**Application for a non-material amendment following a grant of planning permission.
Town and Country Planning Act 1990**

Land to north of Whalley Road, Hurst Green between Warren Fold and School Lane, comprising field and part field and school car park.

Erection of thirty dwelling houses, creation of a new access onto Whalley Road, new estate road, landscape, servicing, a replacement school car park, pick-up and drop-off provision, and public open space, along with demolition of the existing agricultural building.

Plot 01 (House Type K 2075) - First Floor and Roof Plans

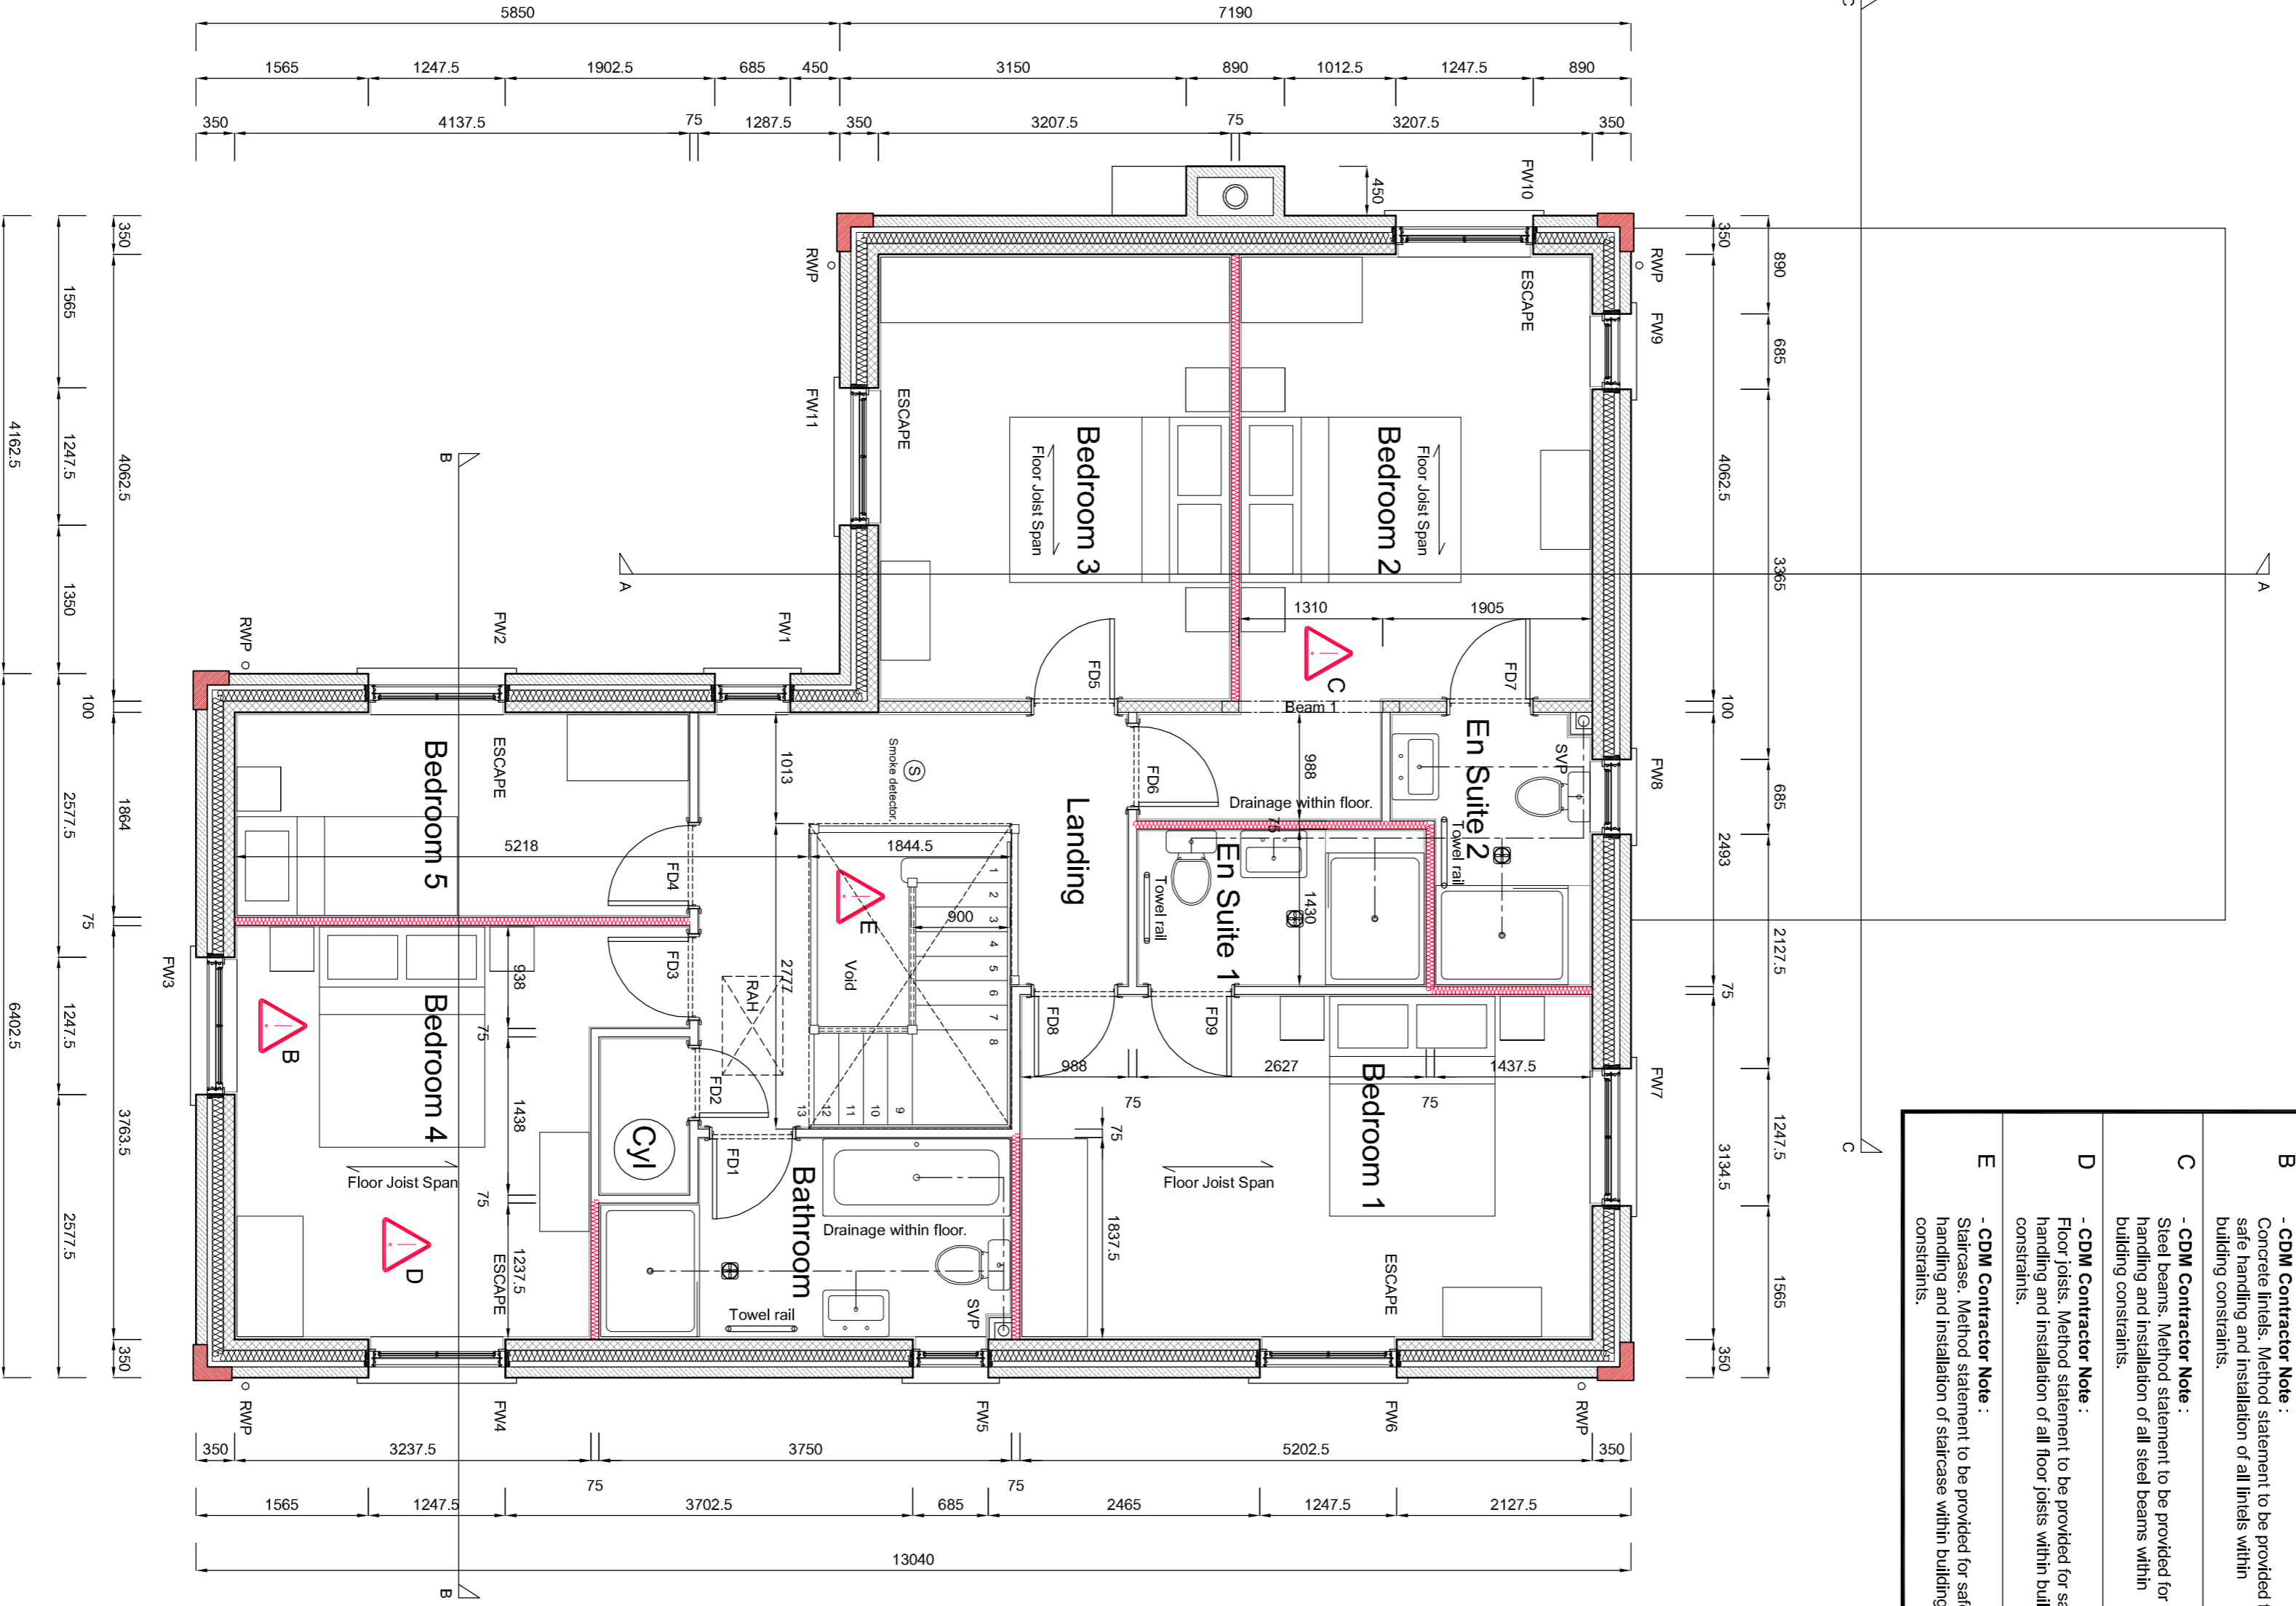
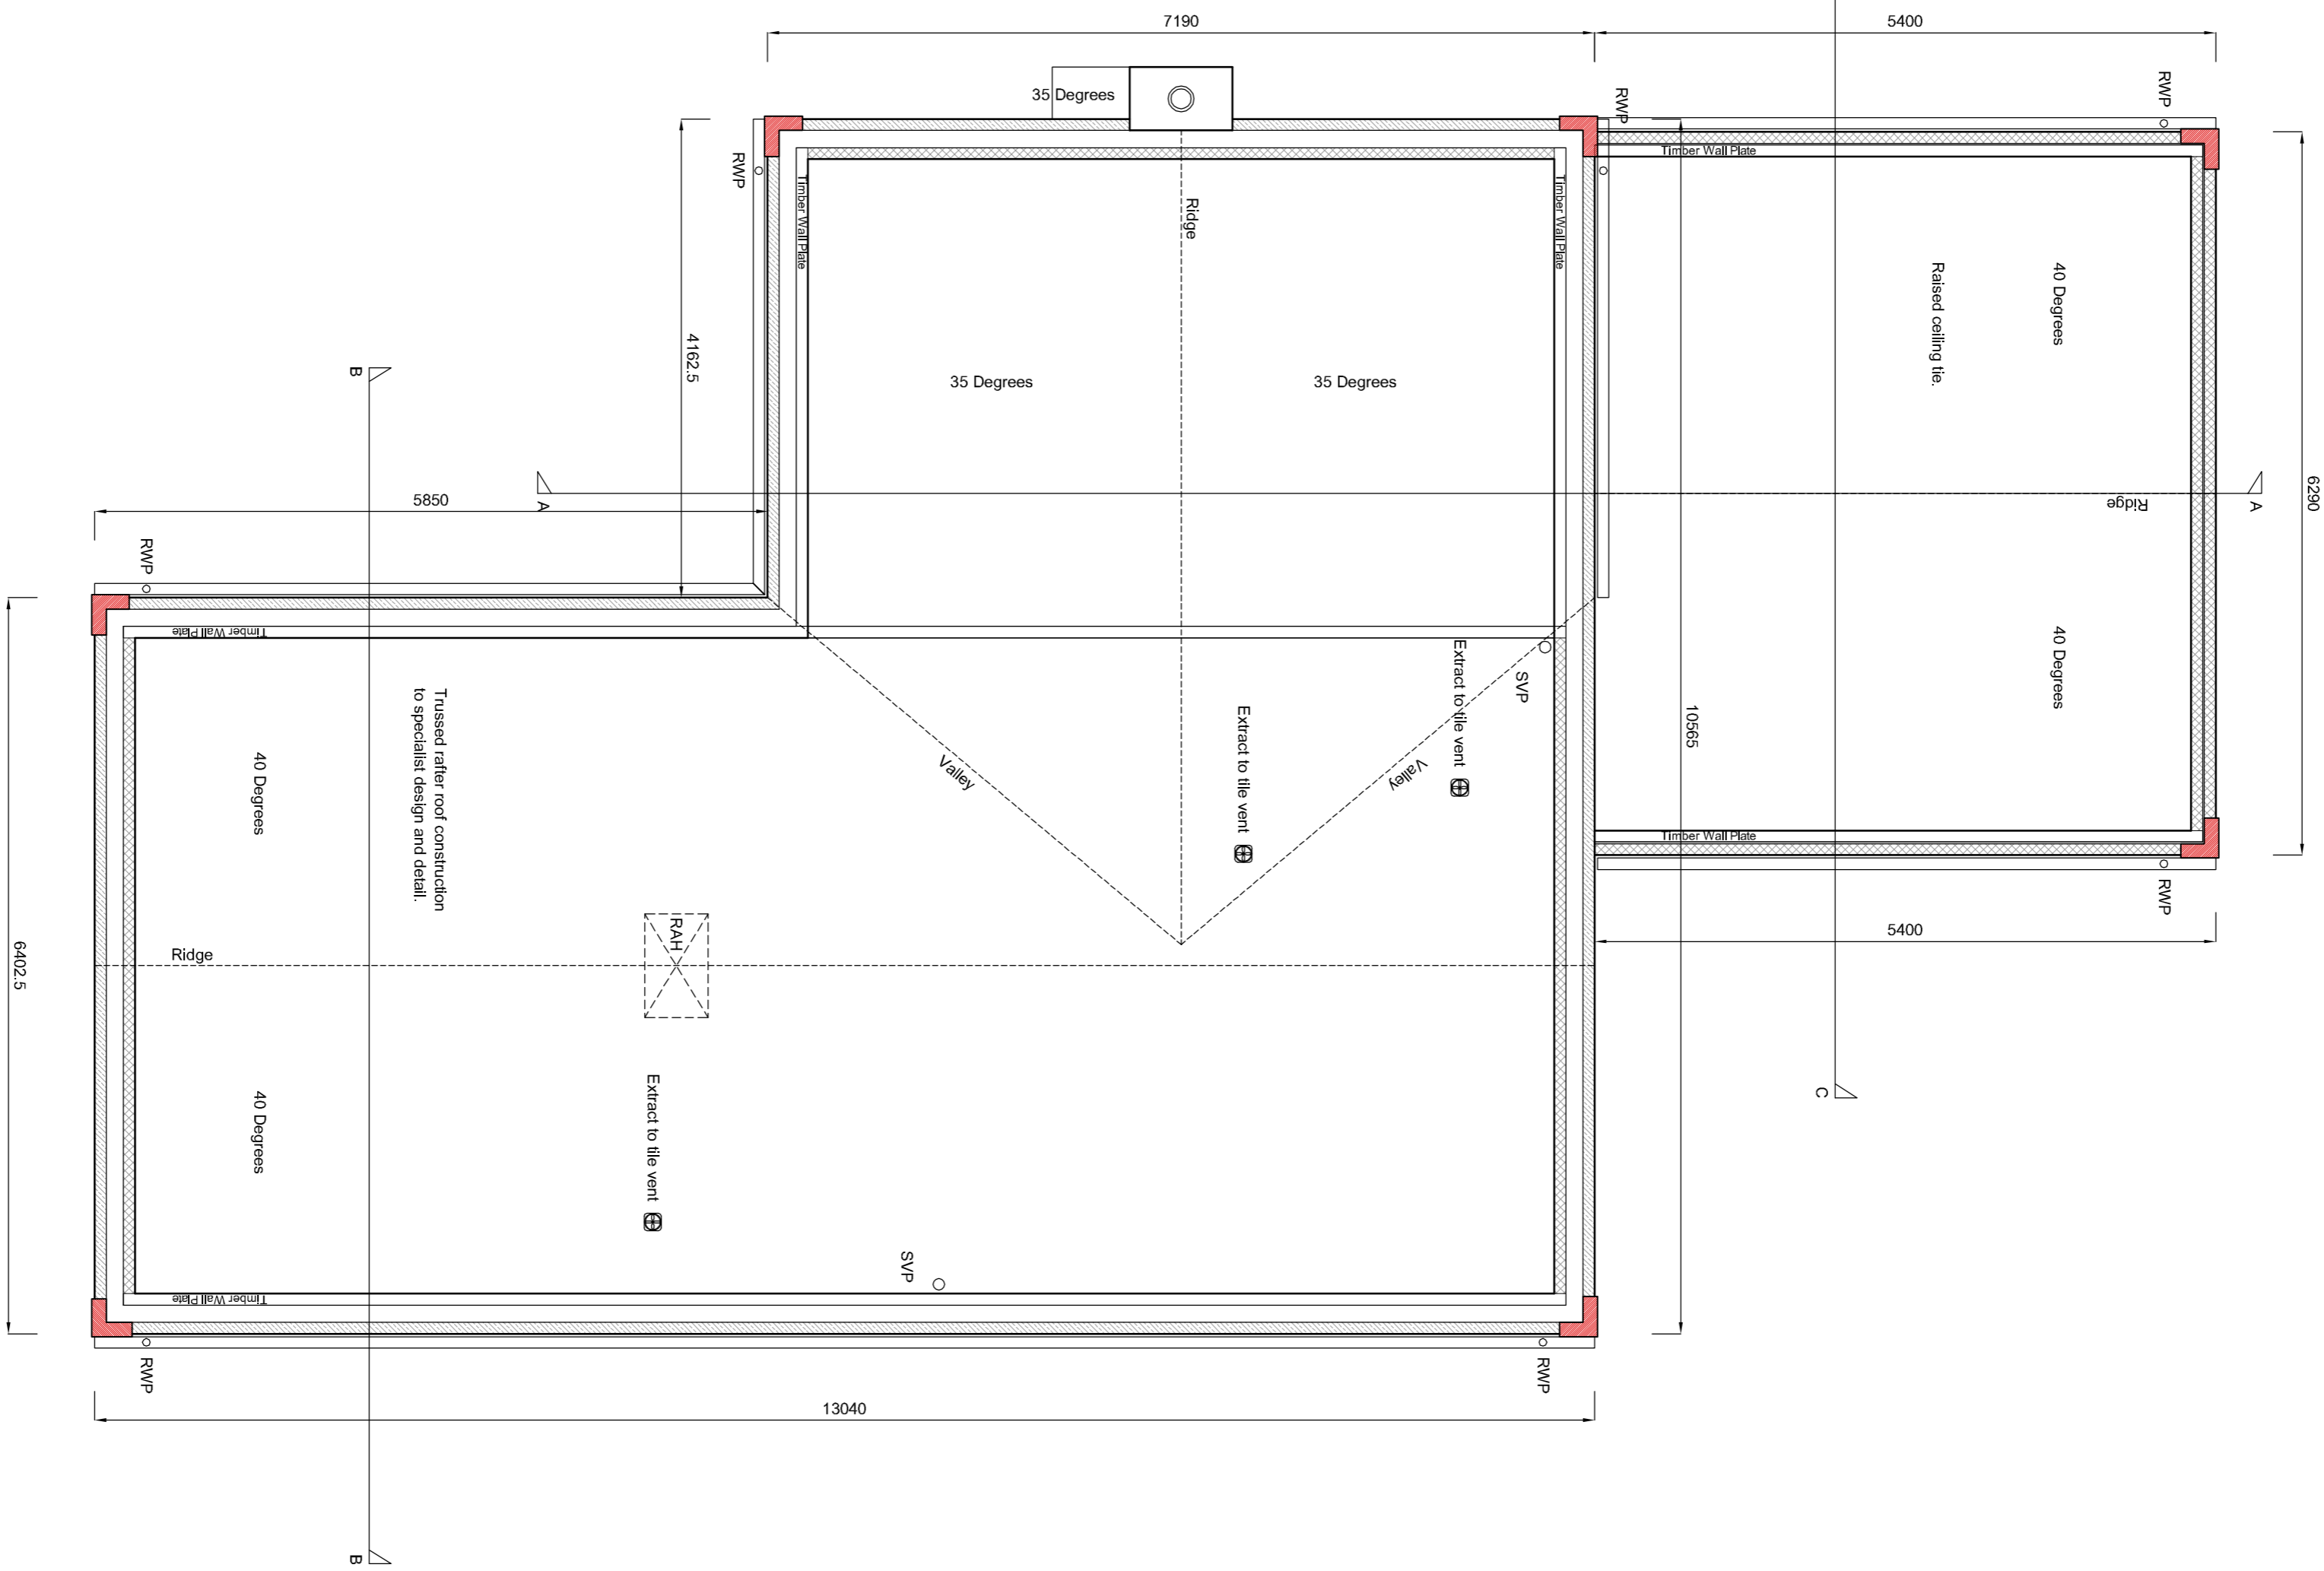
Update of approved materials on detailed elevations of all plots and garages
Revision to house types on plots 18 and 19
Revision to window details to form patio doors on plot 1
Removal of stone piers to driveways with corresponding removal of gates/fencing
Alteration to line of footpath on 'The Green' to avoid tree root protection zone
Revision to private road 5 and private drive to plots 23, 24, 25
